Application for approval of details reserved by condition imposed under planning permission EP/59/17/PL (Appeal no. APP/C3810/W/17/3183667) relating to condition No. 9 (Surface Water drainage works) & 10 (Sustainable drainage scheme)
Tudor Lodge 125A Sea Road East Preston

Thank you for your internet representation made on 15th August 2018 which has been recorded as '**an objection**' with the comments as follows:

L2340-C-52-750 – Drainage for Planning

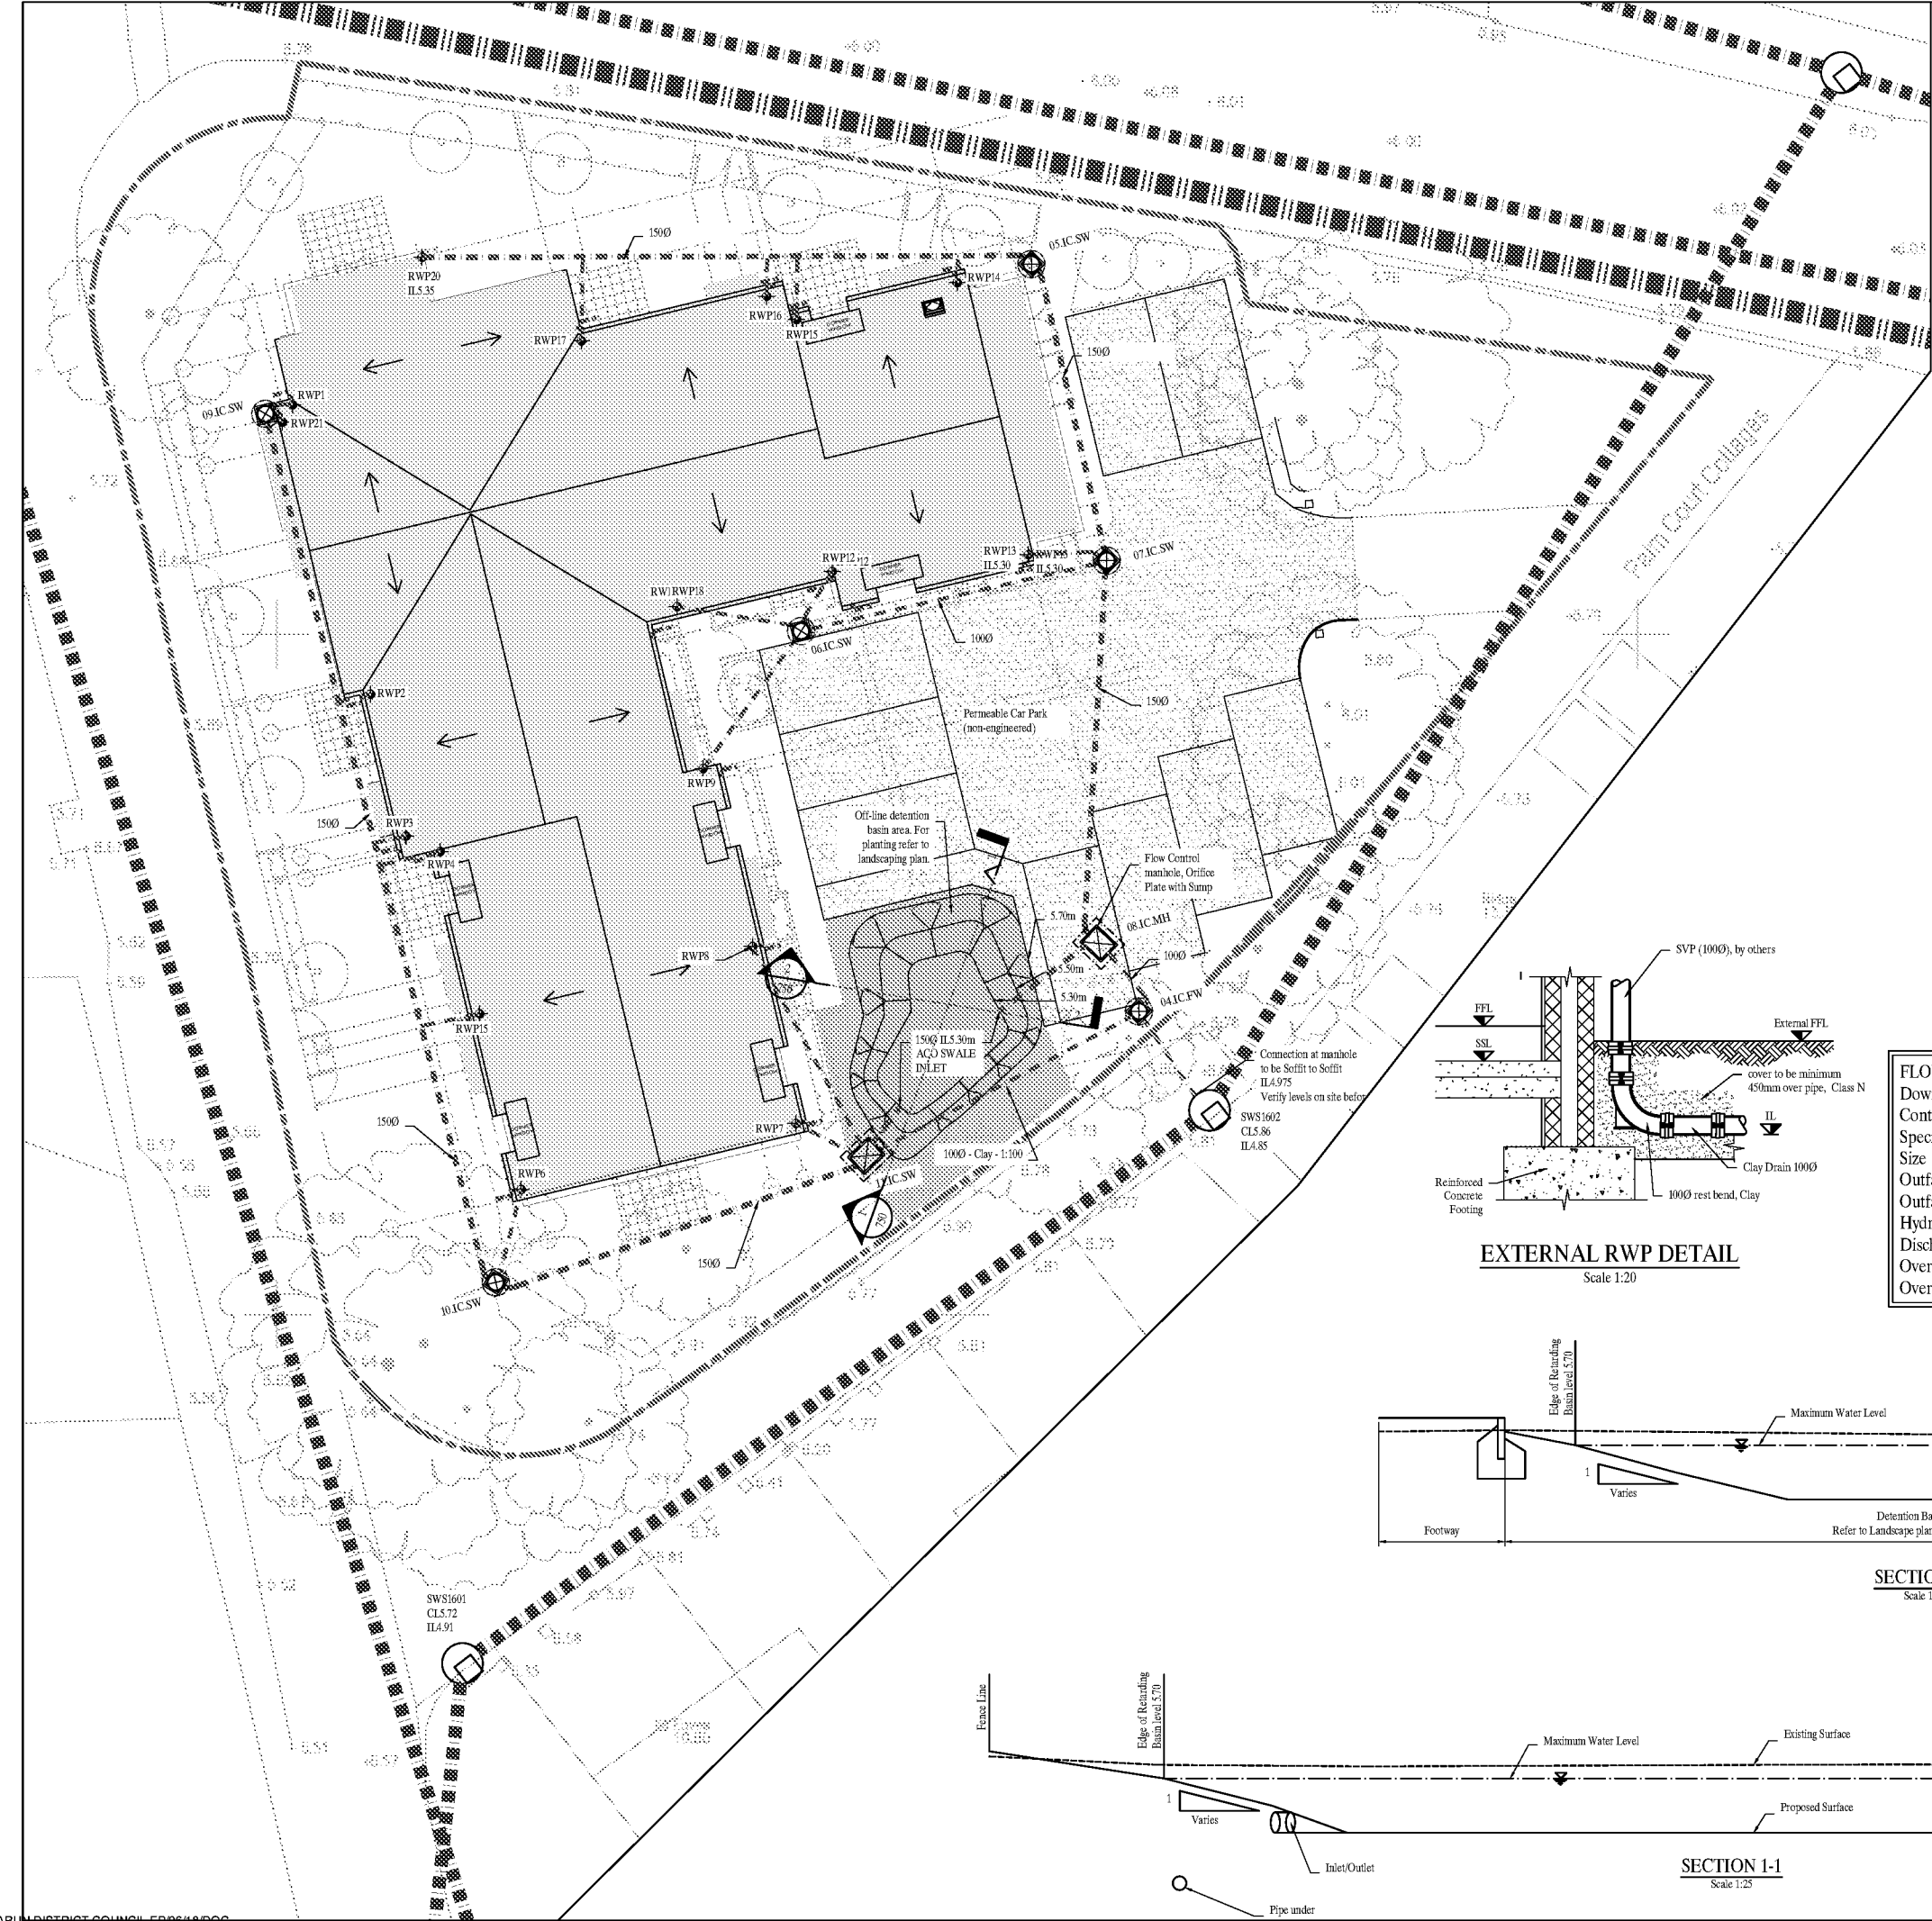
We strongly object to this application for Tudor Lodge to join Palm Court drainage system. We believe that in the past the drains and sewer pipes have become blocked and having to be cleared by the residents of Palm Court or a drain cleaning company. Therefore we do not think the pipe work is suitable for another seven properties to join onto the Palm Courts drainage and sewer system.
